**Re: Modification Request Number 4 for the Glen Innes Wind Farm**

## **SUBMISSION IN RELATION TO MODIFICATION REQUEST NO.4 BY THE GLEN INNES WIND FARM**

Figure 4- Approved GIWF Mod-2 and proposed Mod-4 wind turbine comparison

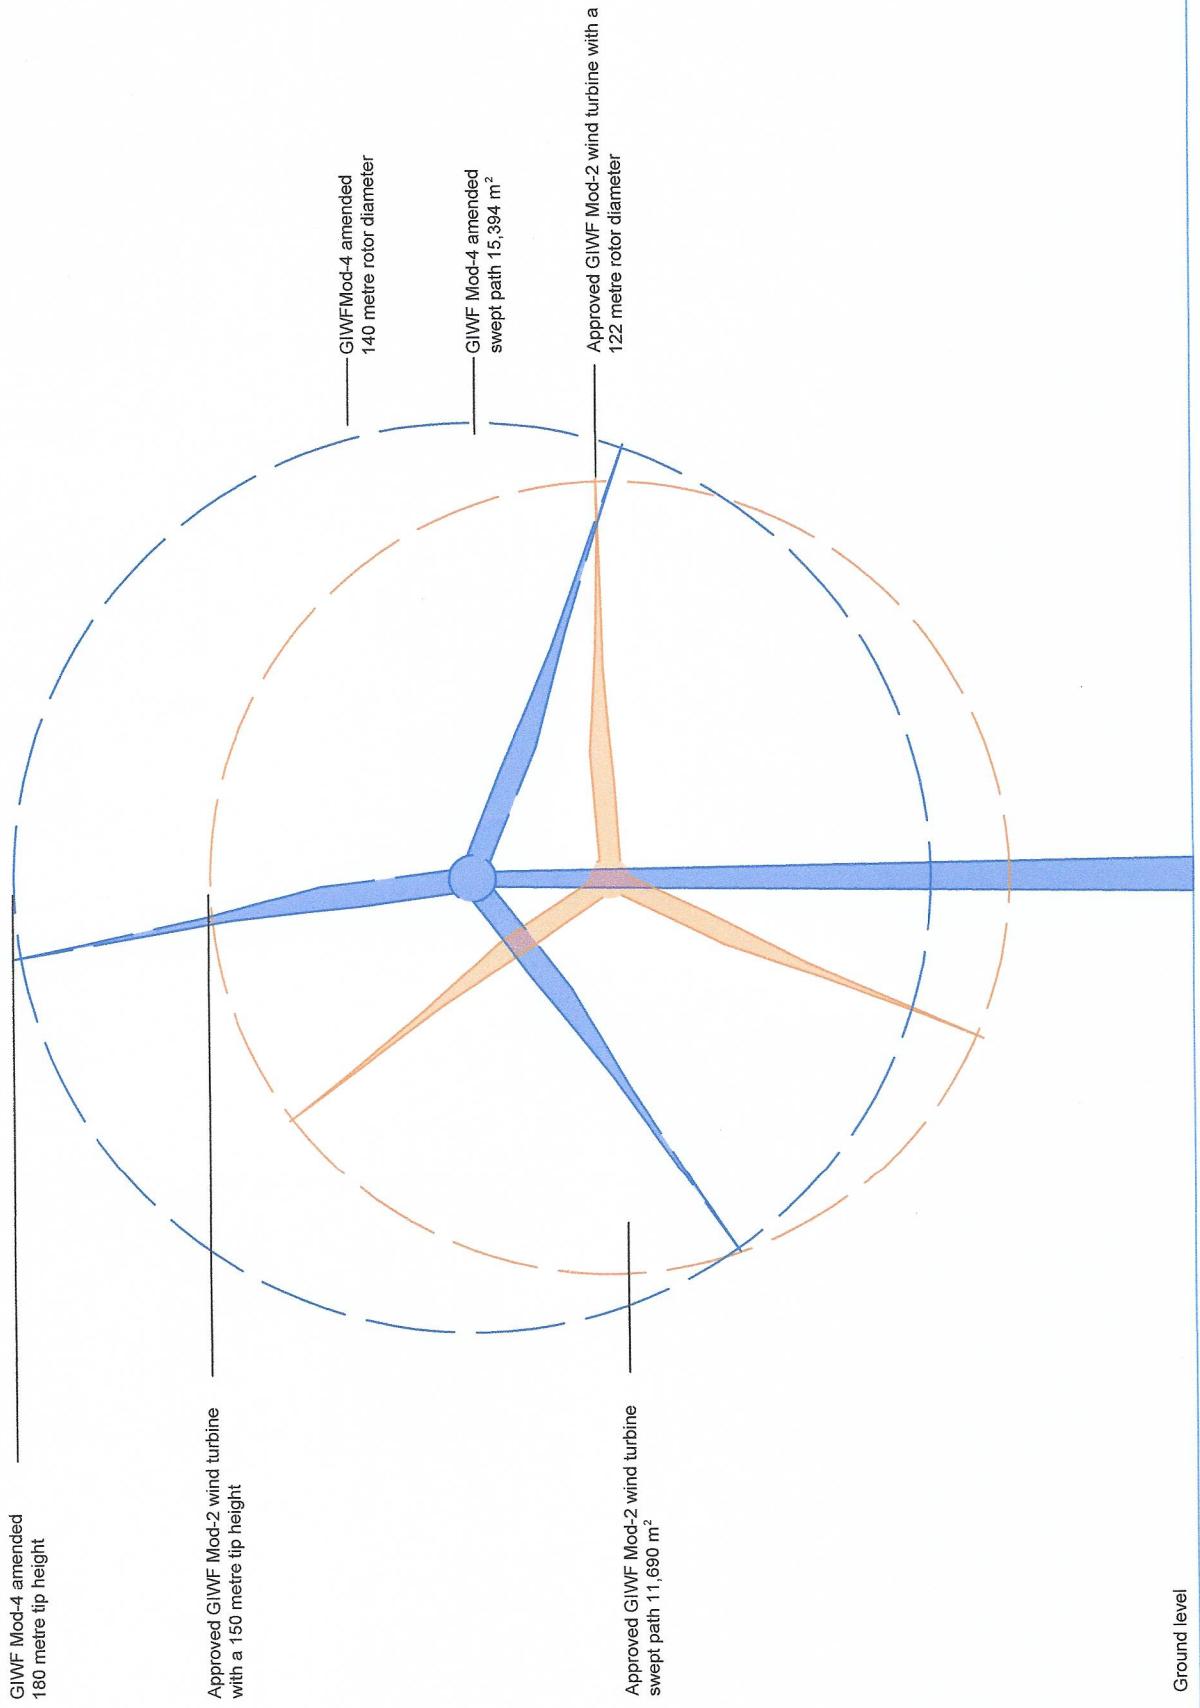
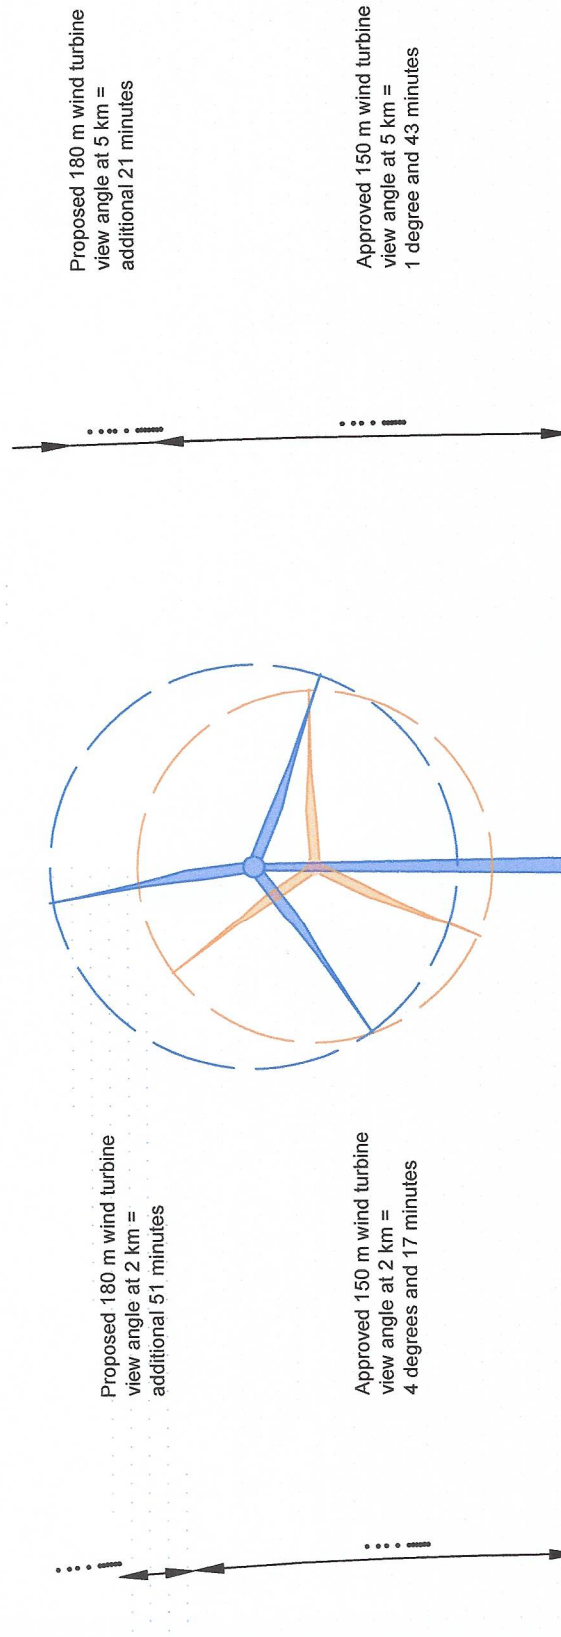
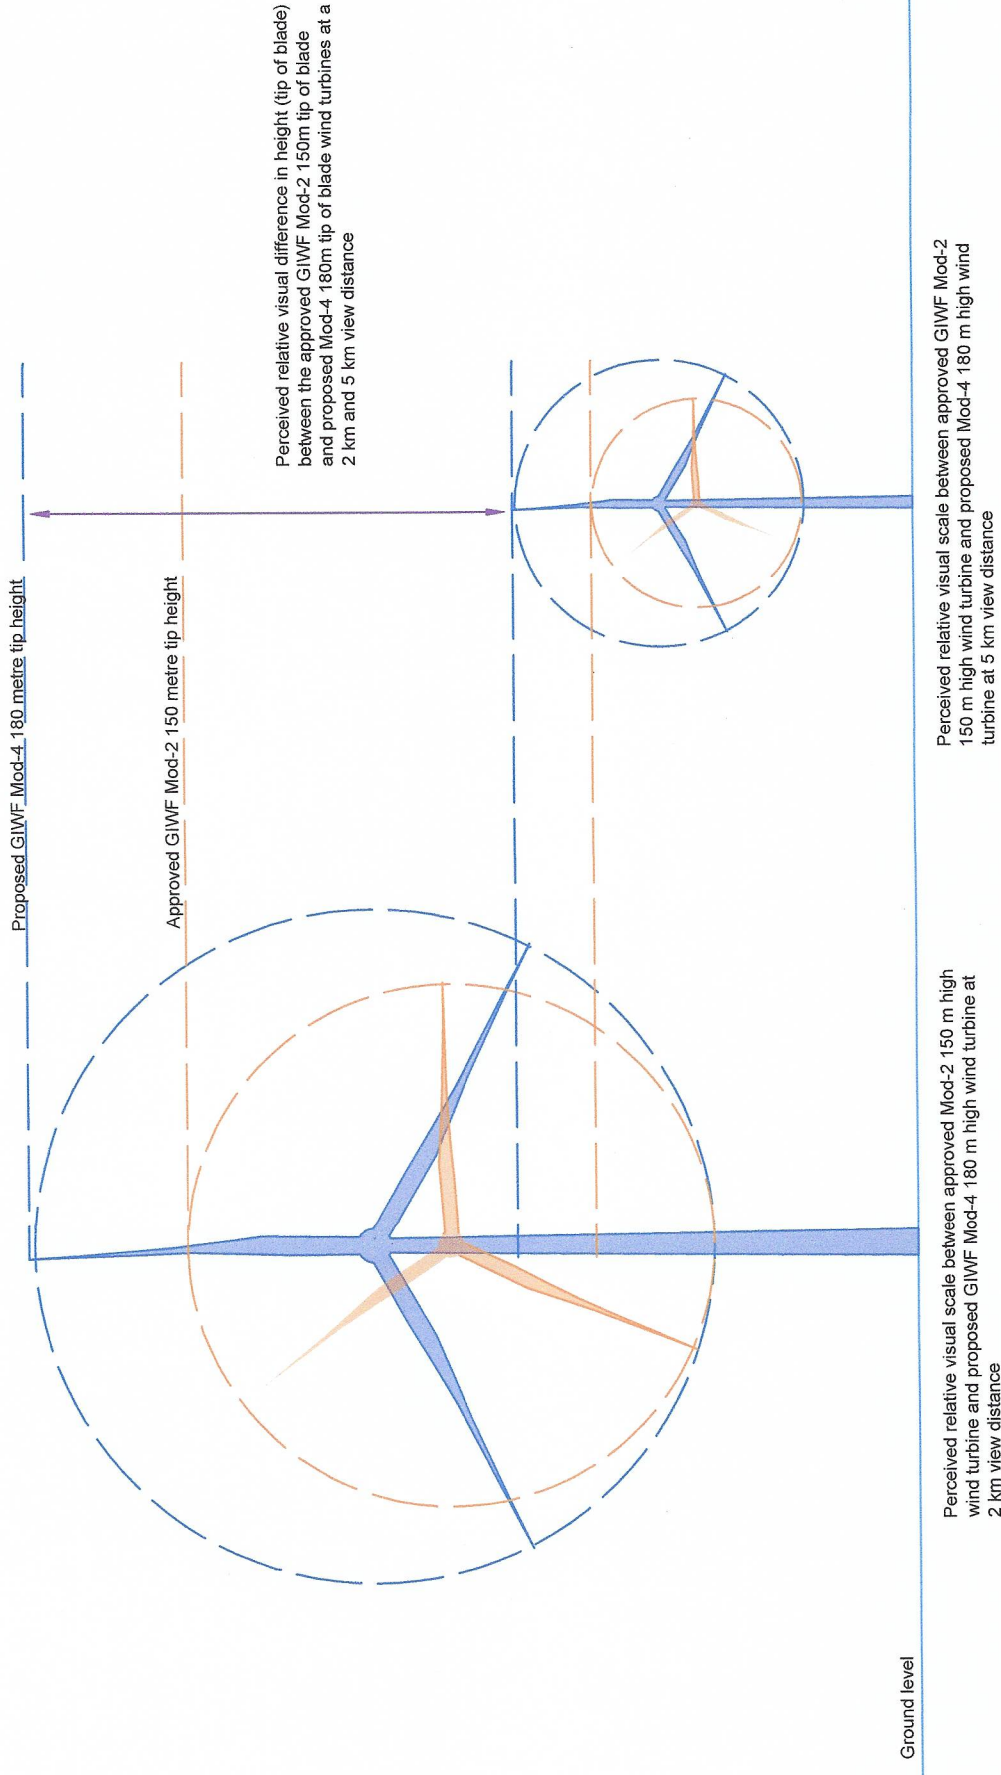
6. The Visual Impact Report prepared by Green Bean Design (GBD) was a “desktop study” with no site visit noted. Without a sight visit, and genuine discussions with each affected resident (which has not occurred) within the 3.6klm boundary (as per figure 1 in the GBD report), how can valid conclusions be drawn about the visual impacts on each property.
7. As per GBD the Modification 4 request by GIWF seeks consent for:
  - A hub height increase of 21 metres from 89m to 110m – a 24% increase.
  - A rotor diameter increase of 18 metres from 122m to 140m – a 15% increase.
  - A tip height increase of 30 metres from 150m to 180m – a 20% increase.
  - A sweep area increase of 3434 sq metres from 11960 sq metres to 15394 sq metres - a 32% increase.

This is a significant increase in visual impact and will have a substantial impact on residences within 3.6klm. How can GBD conclude that this substantial area/visual increase is not a significant change, but rather a minor amendment is beyond me.

9. The GIWF Modification 2 submission listed the visual impacts of the turbines as “Moderate to High”. Despite a substantial increase in the scale of the wind turbines (refer point 7 above), GBD’s report lists the visual impact changes of the Modification 4 request as “Low”. I do not agree with this conclusion of GBD as it is at odds with the comments in GBD’s own report.

A 24%, 15%, 20% and 32% increase in the scale of the wind turbines in Modification 4 would clearly move residences rated as “Moderate in Modification 2” into “High” and those rated as “High in Modification 2” into “Extreme”.
